**NELSON GEOTECHNICAL
ASSOCIATES. INC.**

Geotechnical Comment Response
Moran Residence Development
5028 West Mercer Way
Mercer Island, Washington
NGA File No. 1211520

This letter documents our response to geotechnical city review comments regarding your planned residence at **5028 West Mercer Way on Mercer Island, Washington.**

We have been provided with geotechnical review comments from the City of Mercer Island for the proposed residence development in a plan set markup dated April 27, 2023. In the following section we summarize the review comment followed by our response.

Moran Residence
5000 W Mercer Way
Mercer Island, WA
Parcel # 1924059244

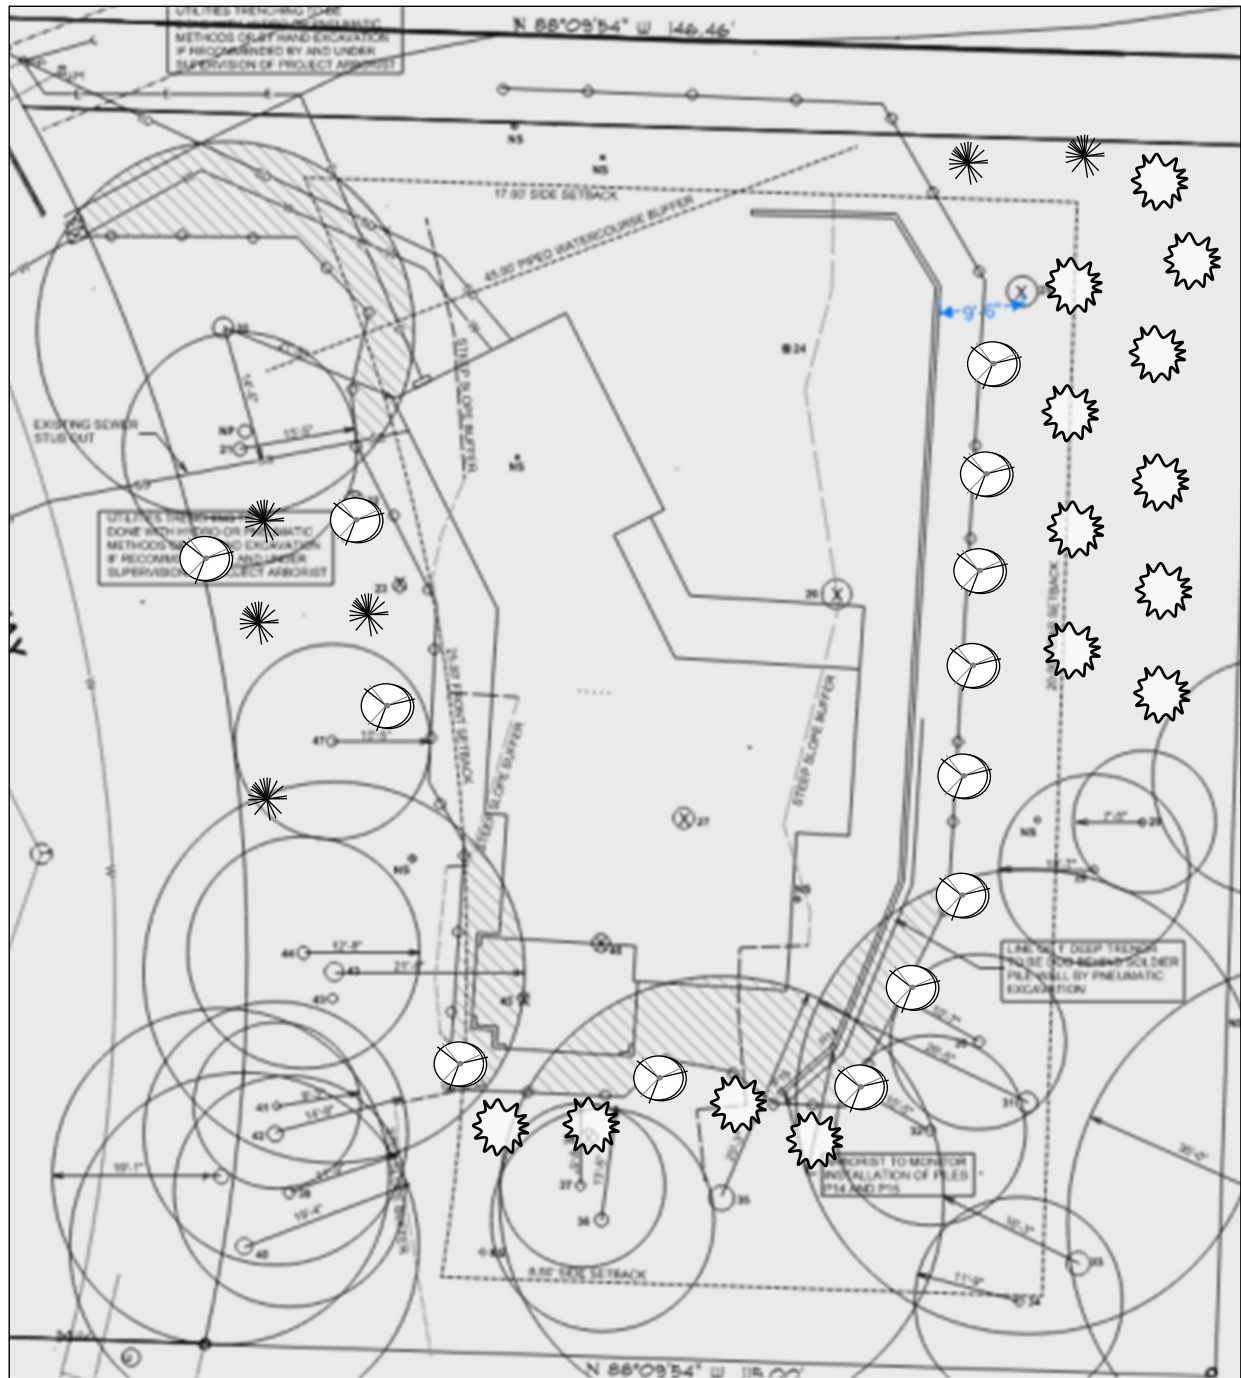
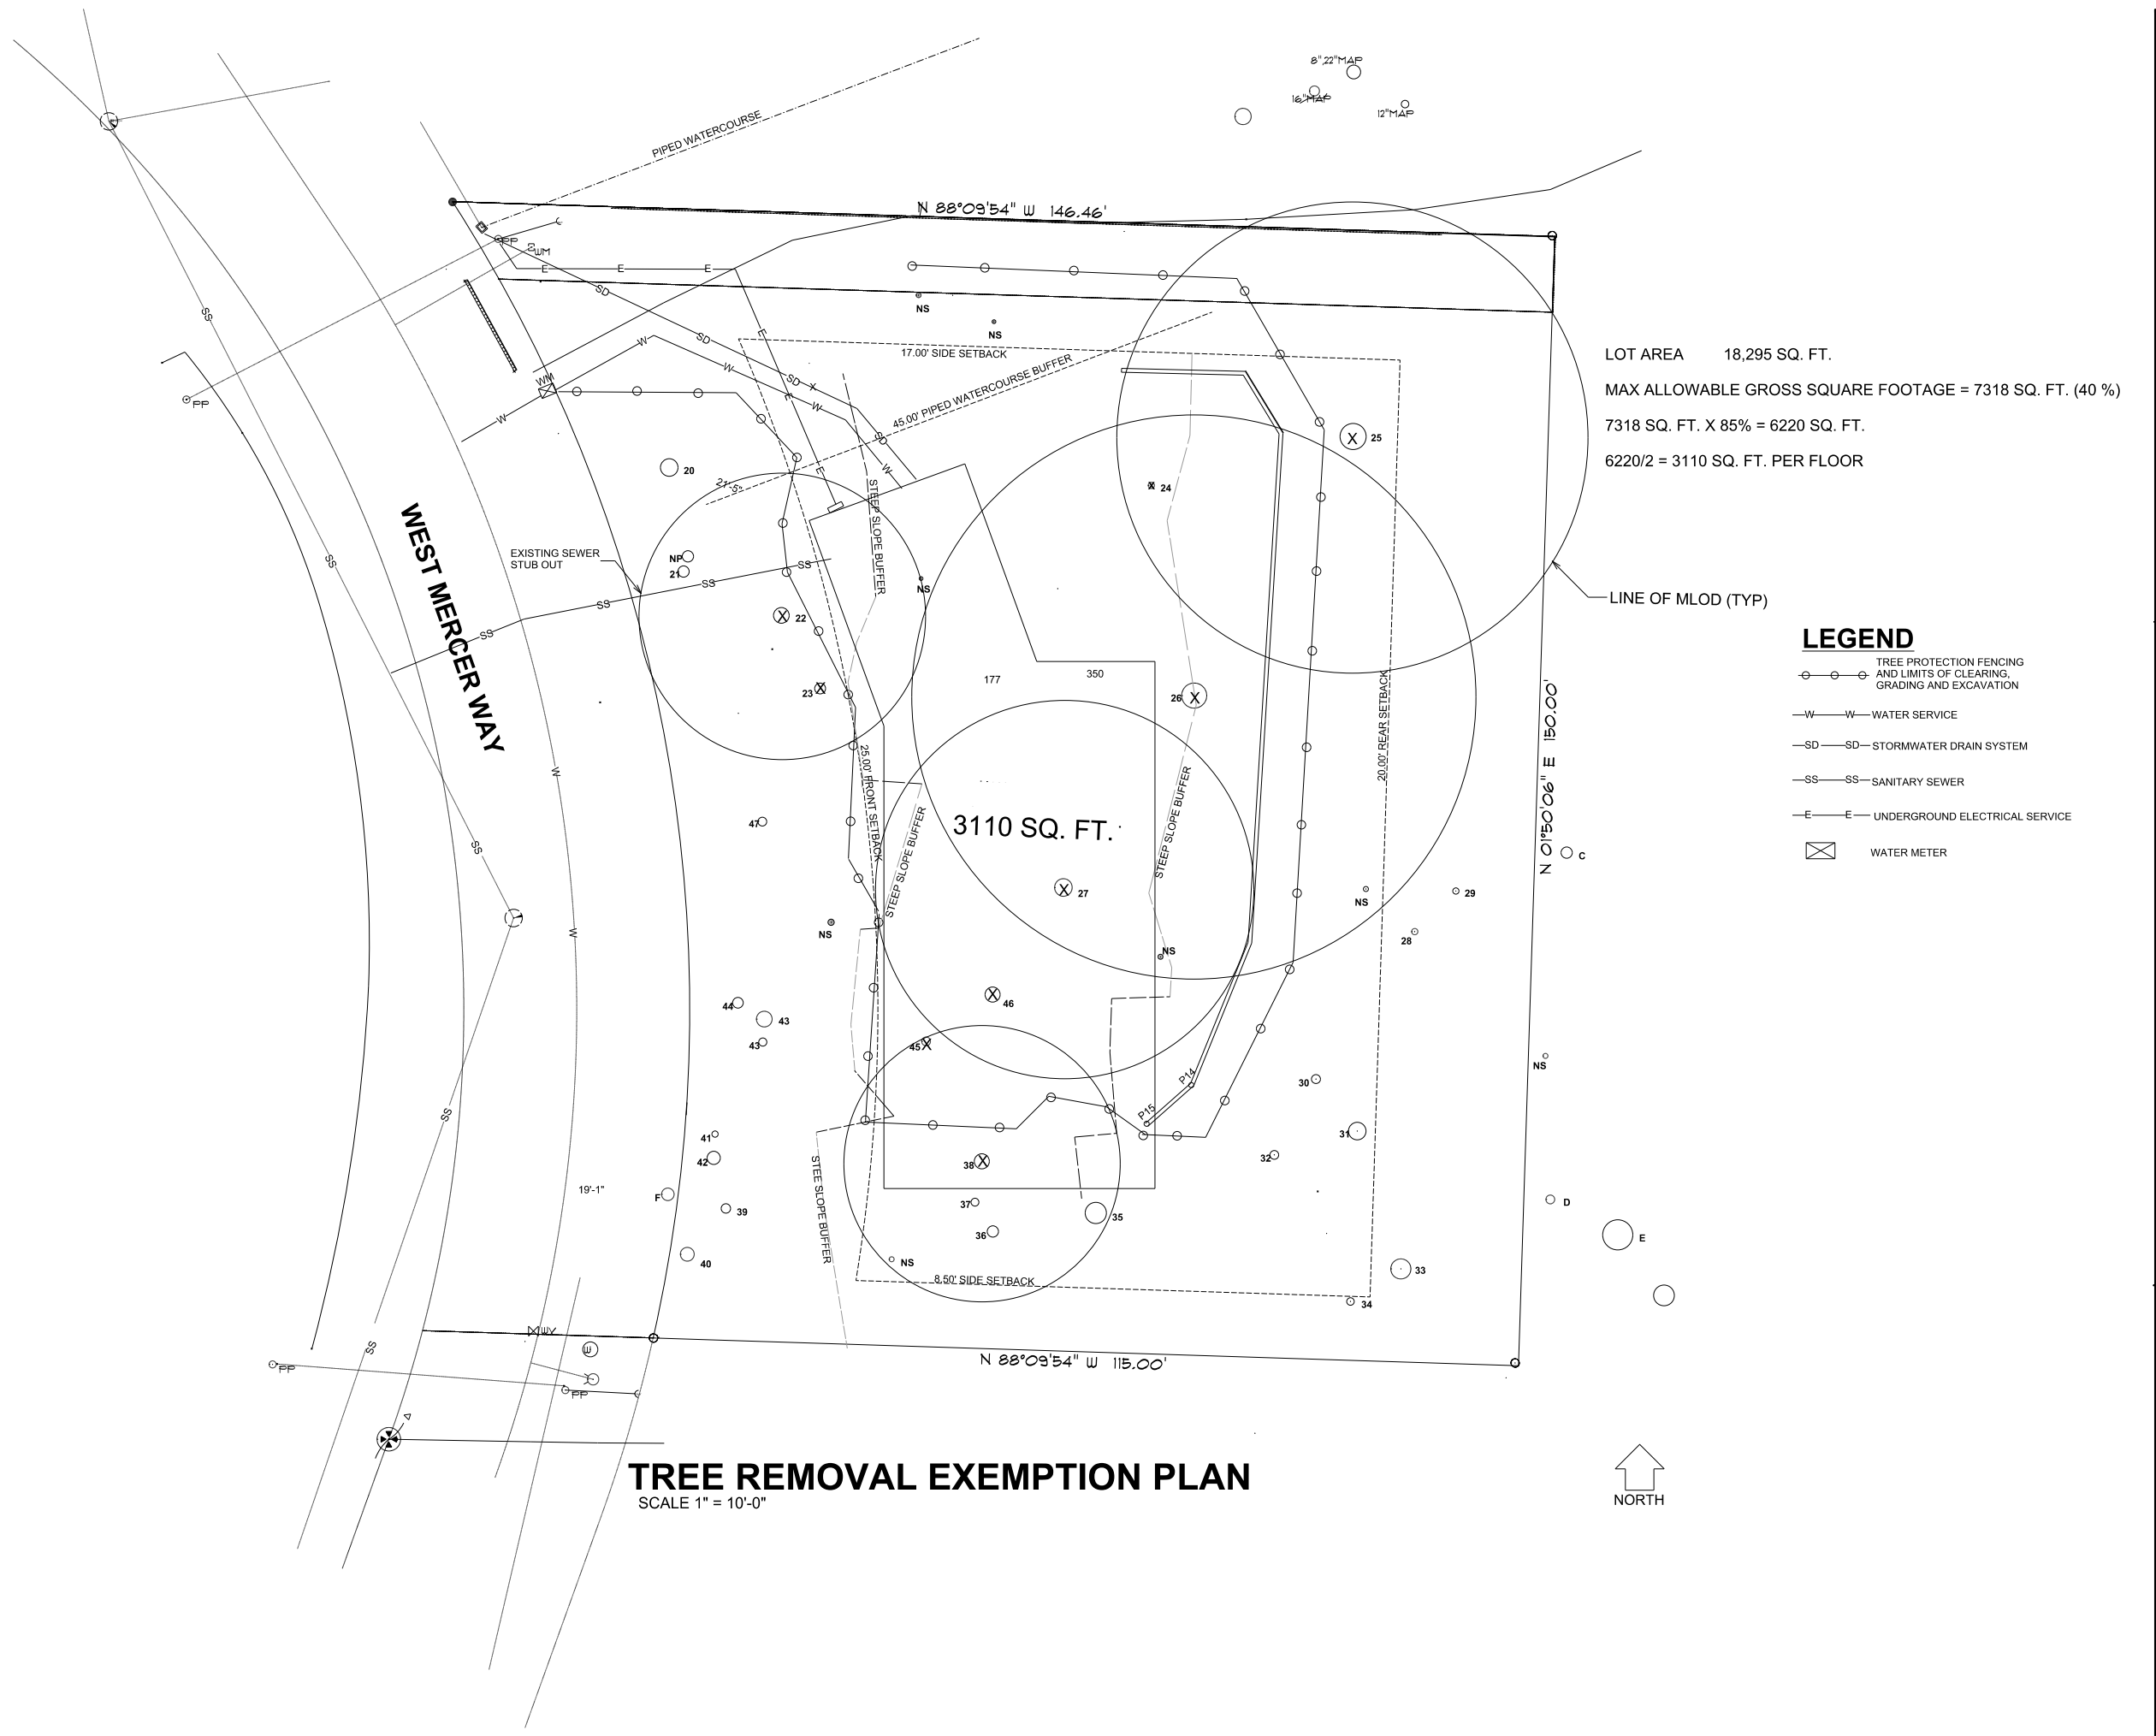
Per the City of Mercer Island Arborist, the geotechnical engineer of record should review and approve landscape plans and verify they conform to the geotechnical recommendations for this site.

We reviewed the landscape mitigation plans sheets L-1 through L-5 titled "Moran Residence," dated February 23, 2023 and prepared by Tree Solutions, Inc. Plans indicate 8 trees to be removed, primarily along the proposed residence location and near vicinity, and replacement of 36 new trees to the east, south, and west of the proposed residence. Approximately 22 new trees, mostly mountain hemlock and douglas fir, are proposed above the planned shoring wall and along the moderate to steep west-facing slope. The plans indicate log rounds should be deliberately placed against the slope to serve as nurse logs. Additionally, temporary irrigation is recommended for new trees. In general, the proposed planting does not present significant geotechnical concerns, however, we do not recommend placing large log debris on steeply sloping areas but could be placed elsewhere on the site in areas of level to gently sloping terrain. Irrigation systems should generally be shutoff during the wet season between October 1 to April 1, as to not contribute to additional saturation of the soils along steeply sloping portions of the site. Upon reactivation of irrigation, the system should be checked and maintained as needed.
